Hampshire Water Transfer and Water Recycling Project

Environmental Statement – Appendix 5.3 Response to EIA Scoping Opinion

PLANNING INSPECTORATE SCHEME NUMBER: WA010002

May 2026

Drawing Number  
 710166-SWS-XX-XX-DR-Z-00

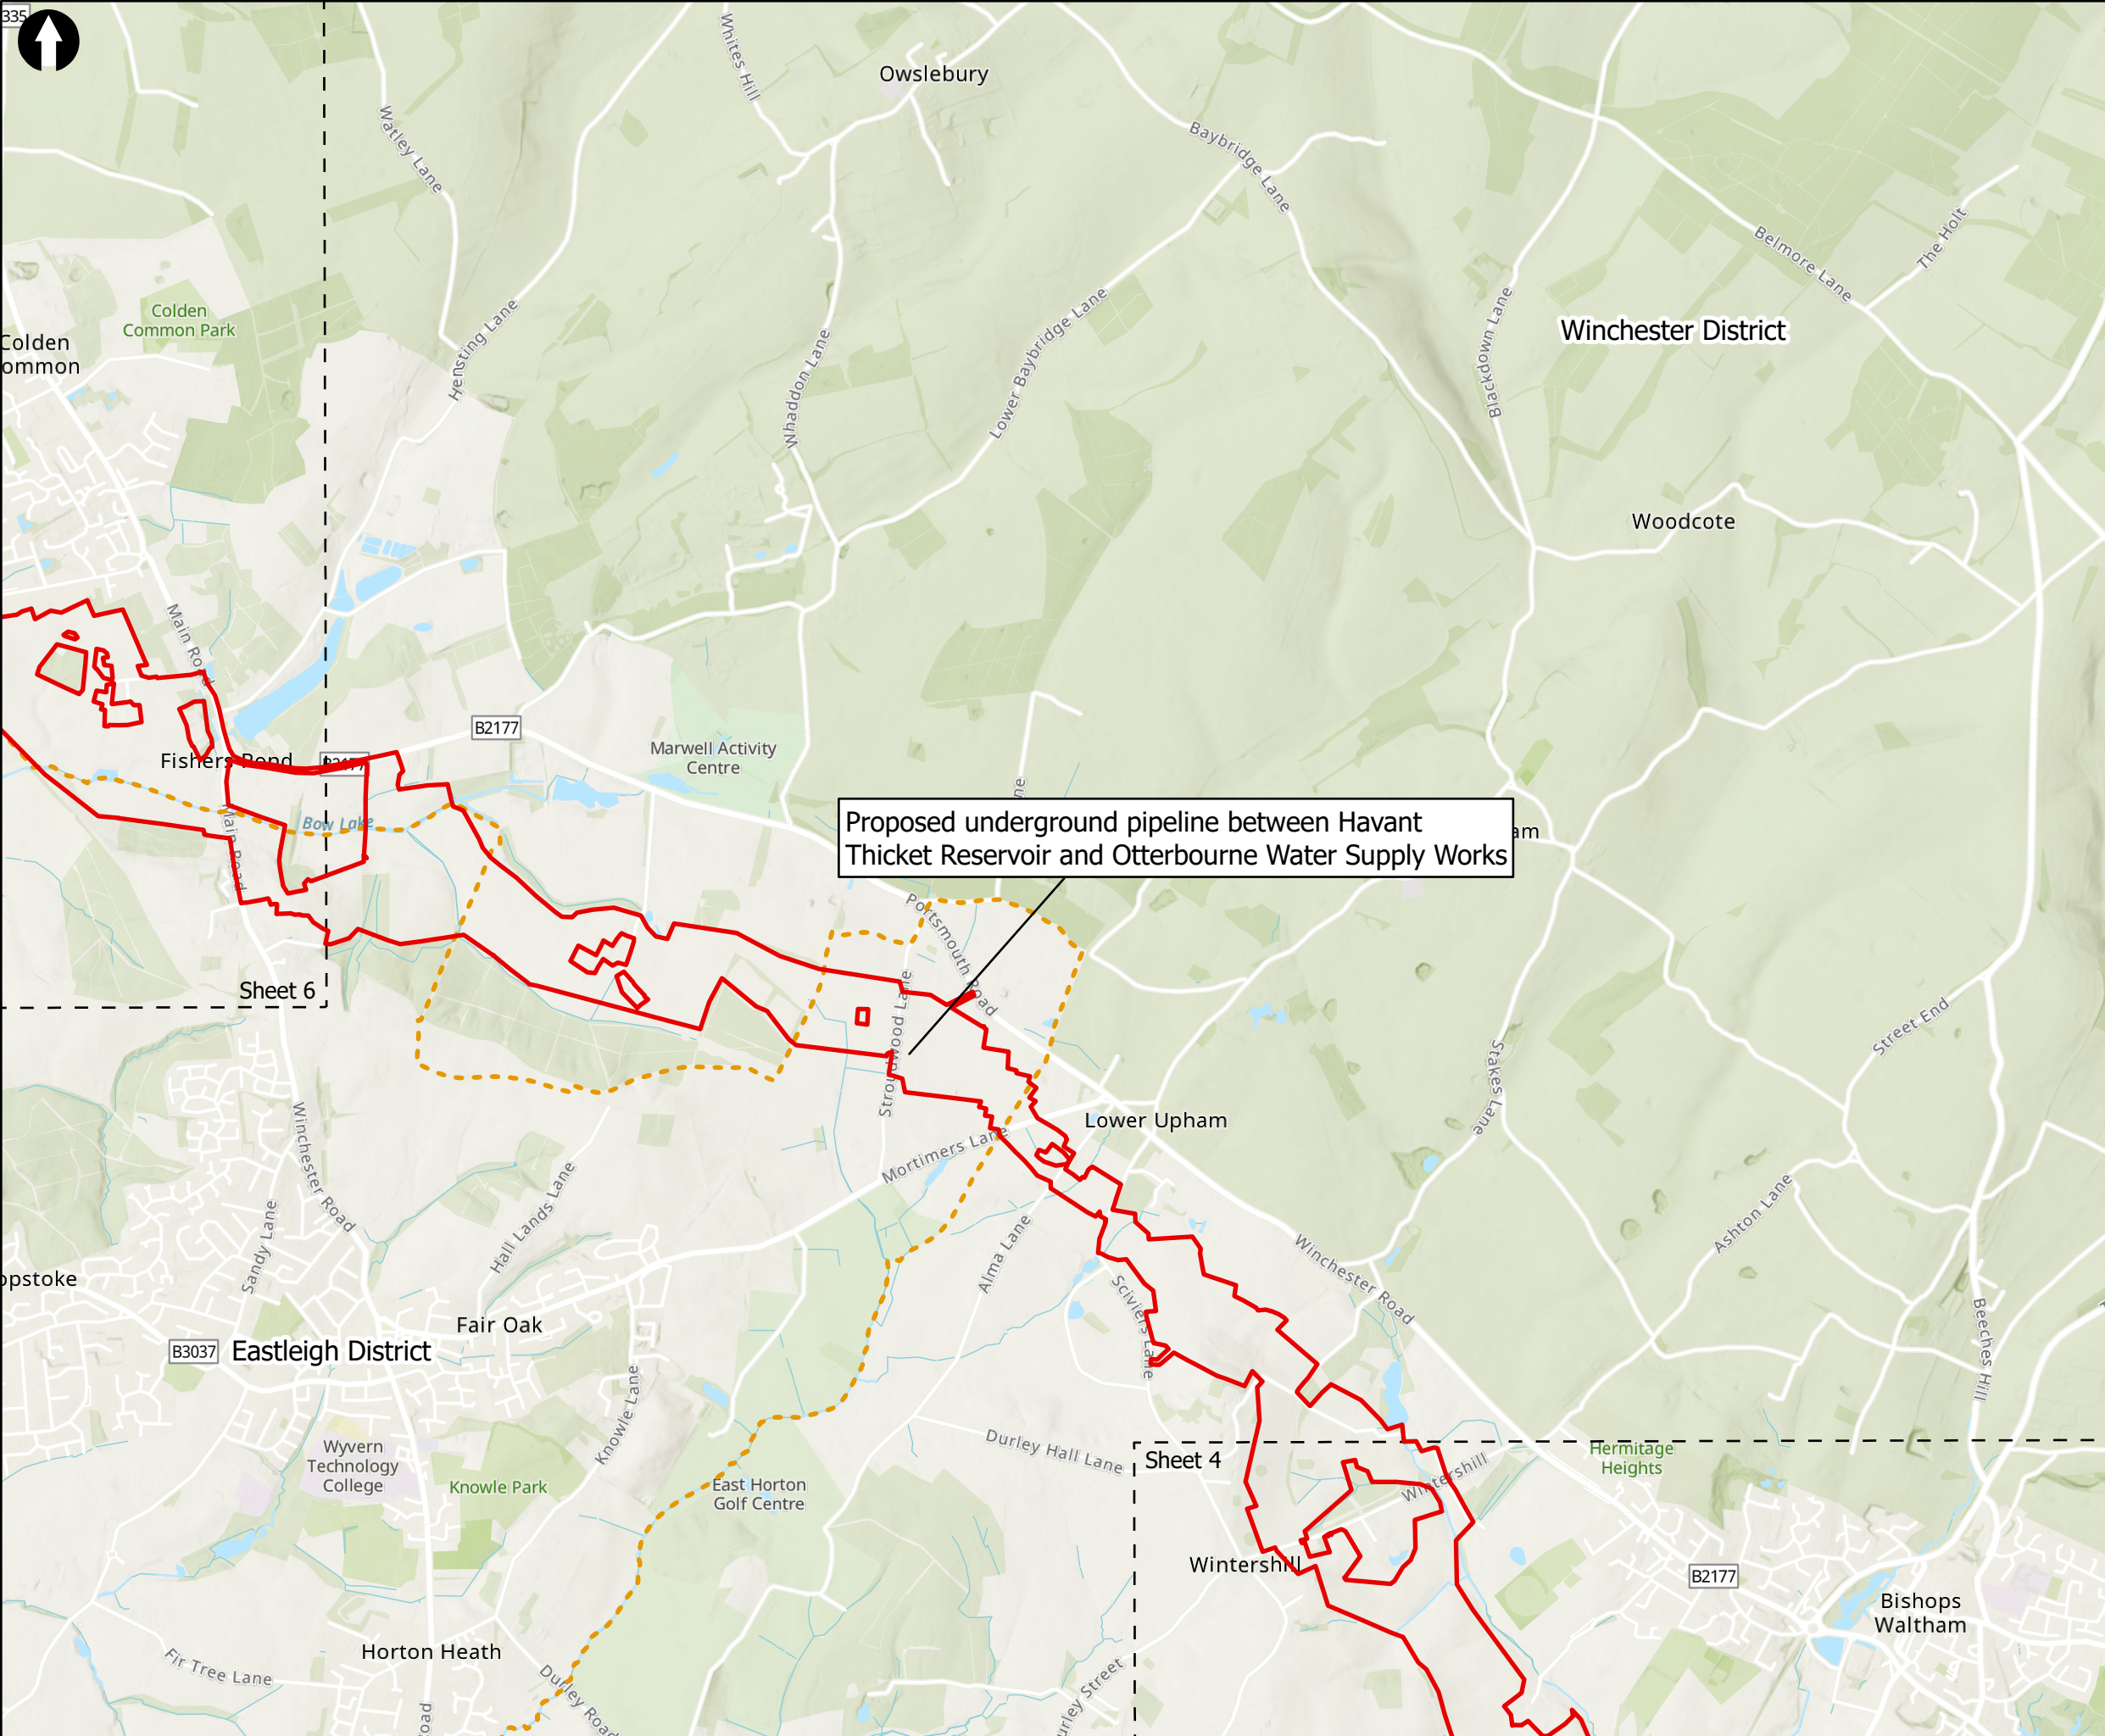
2.2.2	Chapter 4	<p>Order limits: <i>The scoping area shown on Figures 1.1 and 1.2 is proposed to be refined further through scheme development and EIA processes prior to confirmation of the Order limits within the DCO application. The ES should include an explanation of any changes made following scoping, including how environmental effects have been considered in finalising the Order limits.</i></p>	ES Chapter 4 Consideration of alternatives, Volume I (Document reference 6.1, DCO Volume 6), sets out how the Proposed Development has been refined following the EIA Scoping Opinion including how environmental effects, consultation and engagement have been considered. The DCO application includes a Scheme Development Report (Document reference 5.10, DCO Volume 5) which provides a detailed description of how the design of the Proposed Development been developed.
